DEVELOPMENT HEARING OFFICER

PR-2024-009995

VA-2024-00036 – WAIVER TO IDO
IDO - 2022

REQUEST: WAIVER TO UNDERGROUND REQUIREMENT OF NEW ELECTRIC DISTRIBUTION FEEDERS

Prosperity Feeder 11

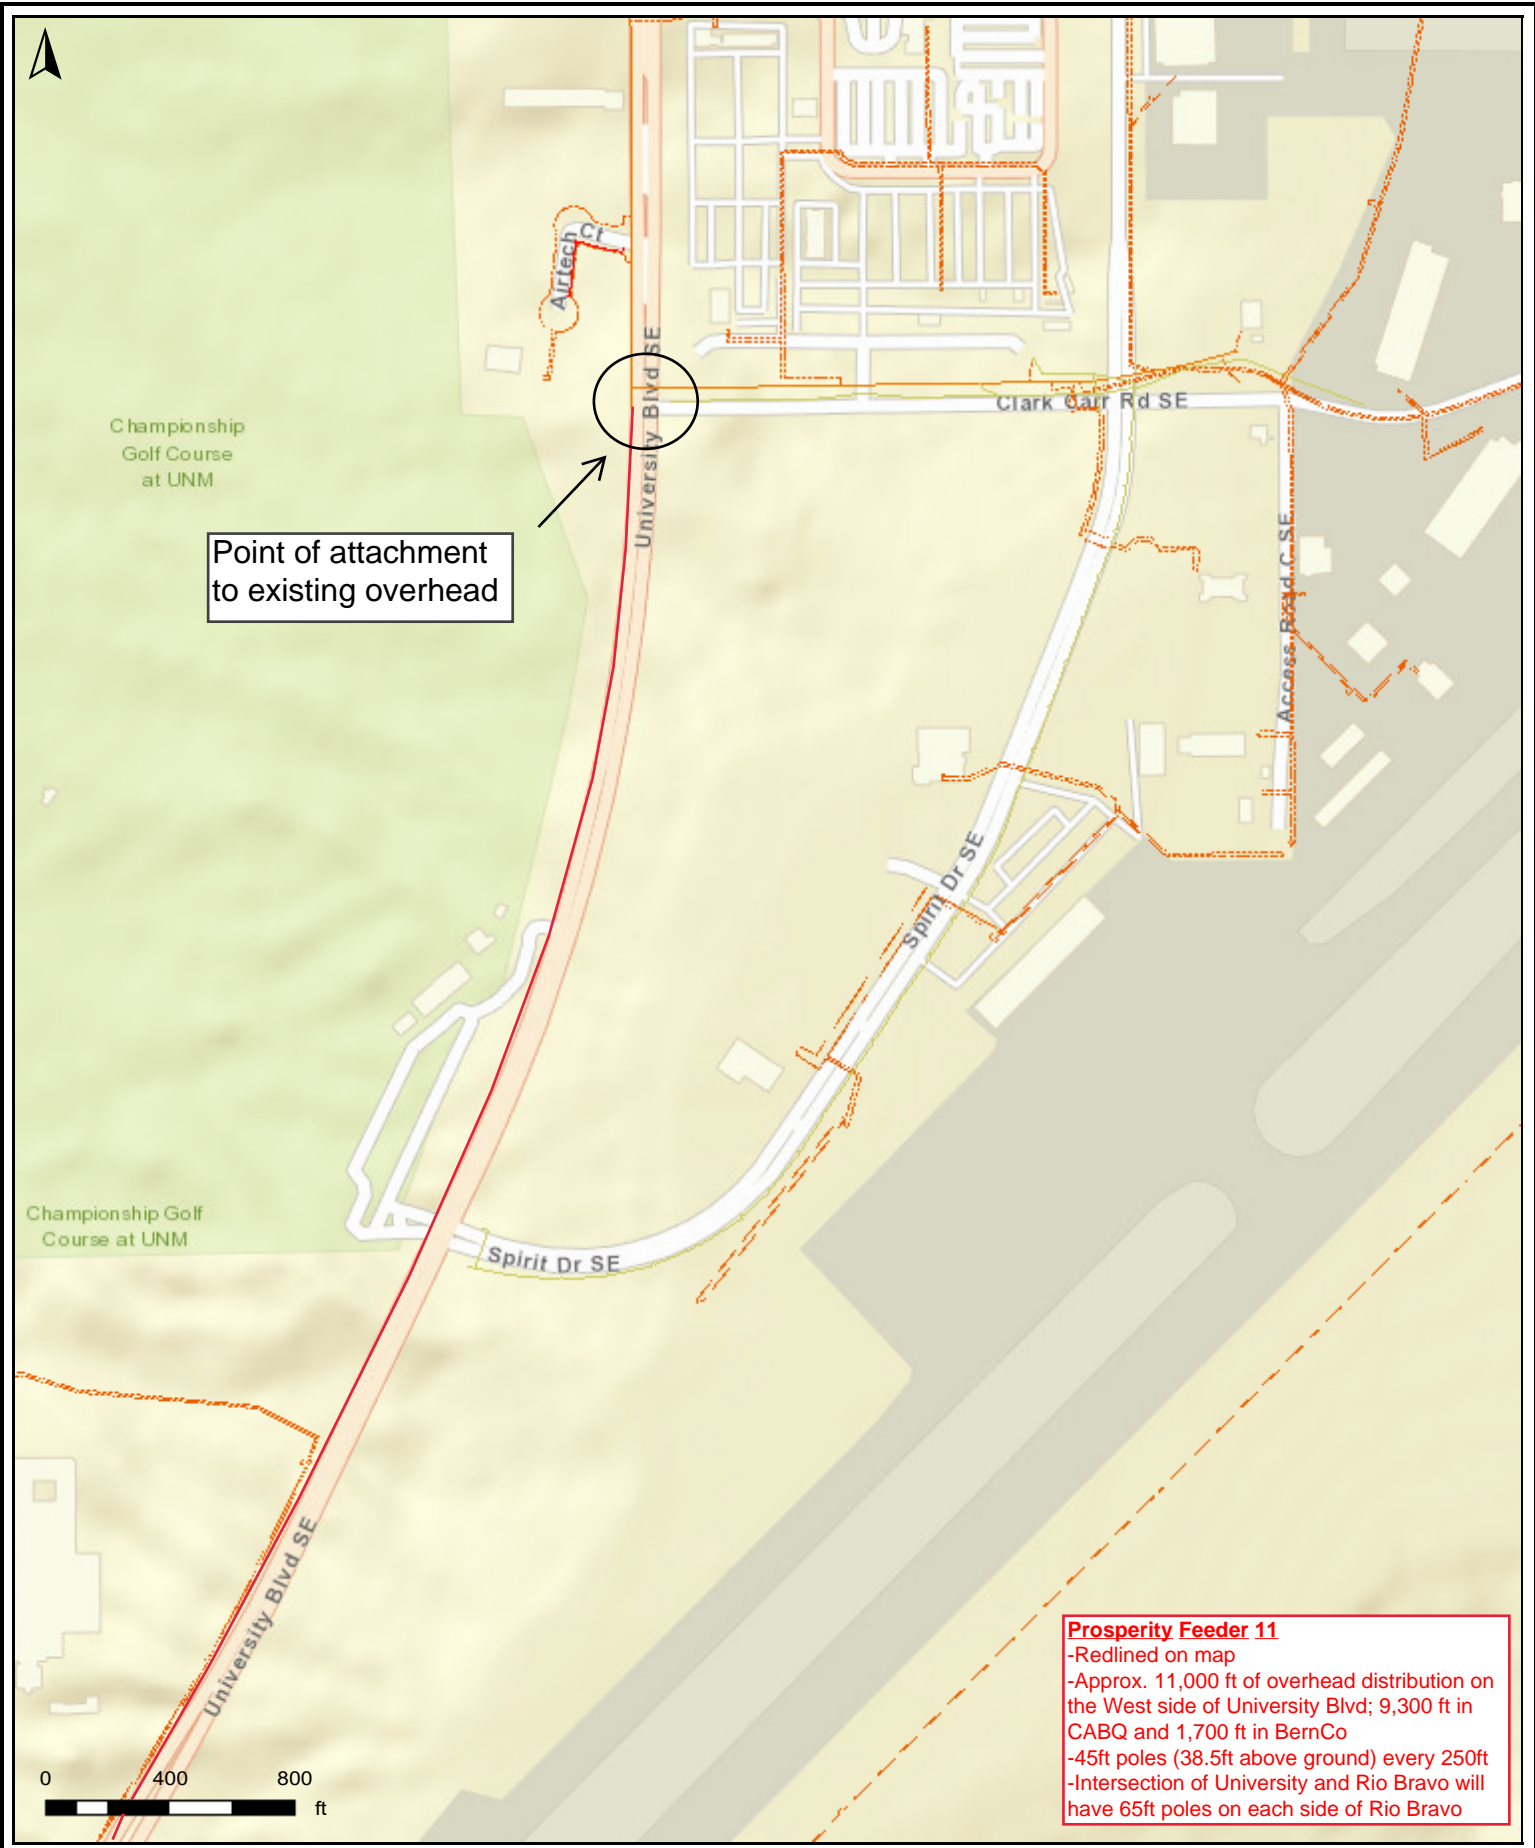
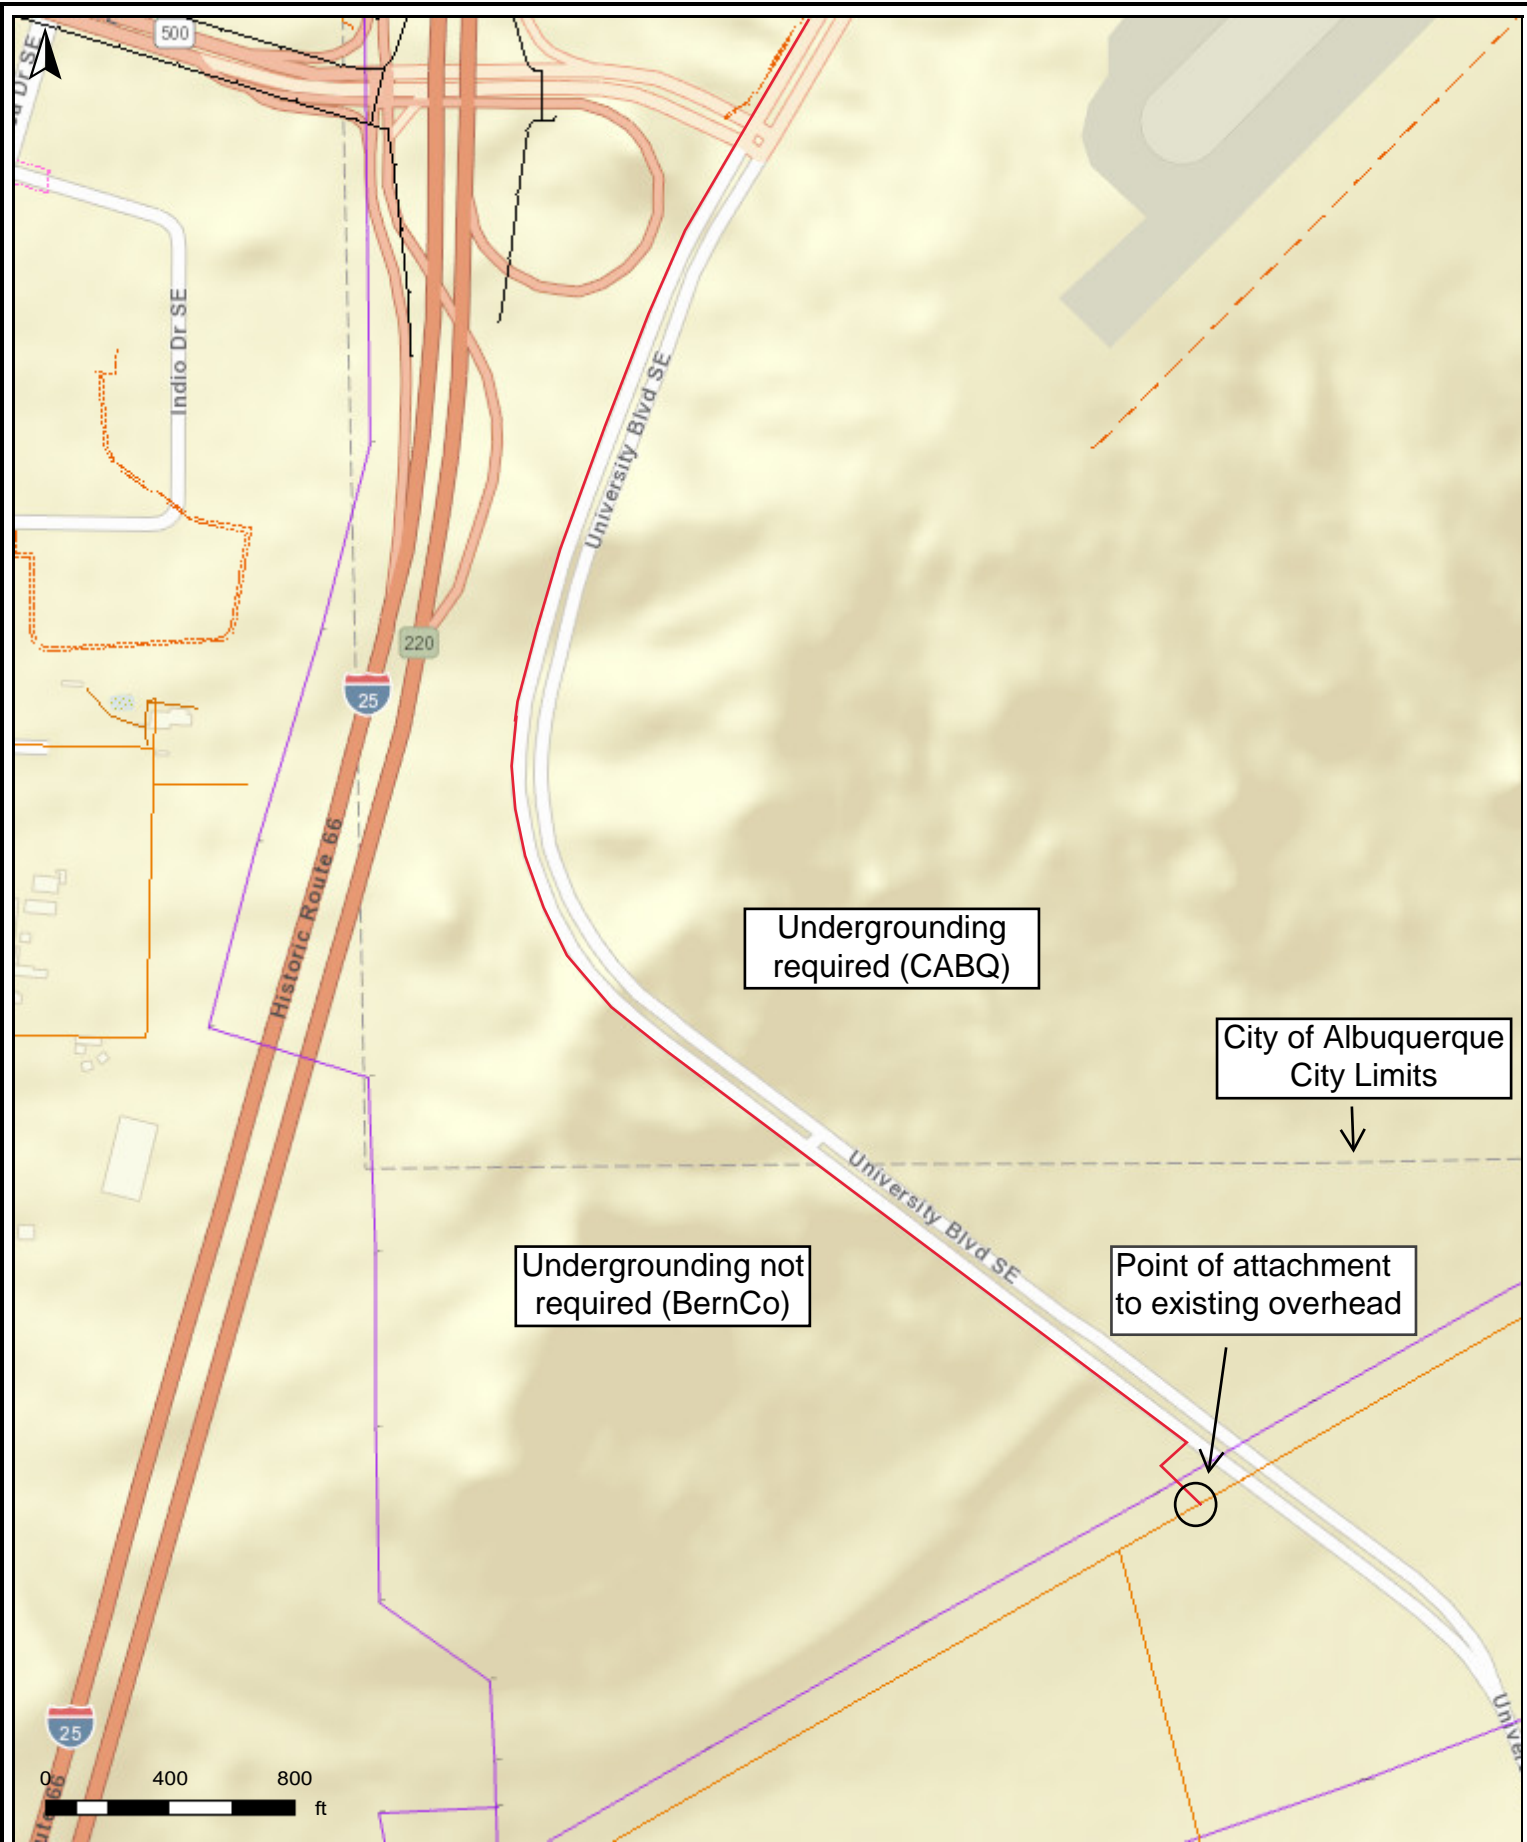
1. Provide proximity to the existing Water Authority infrastructure and a detail of how far PNM will remain from the infrastructure.
2. Please note that there is currently infrastructure along the West portion of University and appropriate review of plans with opportunity to comment will be required prior to installation or any approvals to ensure proximity to any public water and/or sanitary sewer infrastructure is adequate for operation and maintenance purposes.

1. Right-of-way on the west side of University appears to be pretty tight in several locations and the City has a multi-use trail on this side of the road. All poles would need to avoid the trail and any other City facilities along the roadway.
2. Please provide a diagram showing the right-of-way, roadway, trail and proposed location of your powerline at a scale where it is visible how the poles will sit in relation to the trail to help determine if this is possible.

2. The placement of overhead lines on the west side of the University conflicts with the water and non-potable water lines already in place on the west side of the University. The applicant has failed to analyze how the distribution lines would fit with the 'as-built' conditions. The power poles cannot be placed on top of the water easement because they would interfere with maintenance of the two waterlines. The Water Utility Authority has raised concern about the distribution lines being over the water easement. **A public purpose would be served to protect the water easements without introducing conflicting electric poles that could impede maintenance of the water lines. Electric lines underground on the east side of University would avoid this utility conflicts.**

3. There is a multi-use trail from Clark Carr to Los Picaros on the west side of University. The overhead lines could be contrary to the recreational value of the trail. Parks and Recreation has indicated that a 2- foot clearance on each side of the trail must be kept for safety and maintenance. The applicant has not shown the 'as-builts' for University Avenue which would show if there is adequate room for above ground poles with proper safety clearance to the trail. Air photos show that the fencing, which may or may not indicate the ROW, is directly west of the trail in some locations. **Undergrounding would serve a public purpose to preserve the multi-use trail in this corridor.**

4. The west side of University includes the UNM Championship golf course and Jabill business. The Jabill business is the only segment where there is mature landscaping, i.e., a row a mature, tall trees, adjacent to the sidewalk/trail. The second PNM submittal shows a rerouting of the overhead lines to avoid the Jabill site which would be necessary. **The overhead distribution lines and poles would have a somewhat negative effect on the UNM Golf Course.**
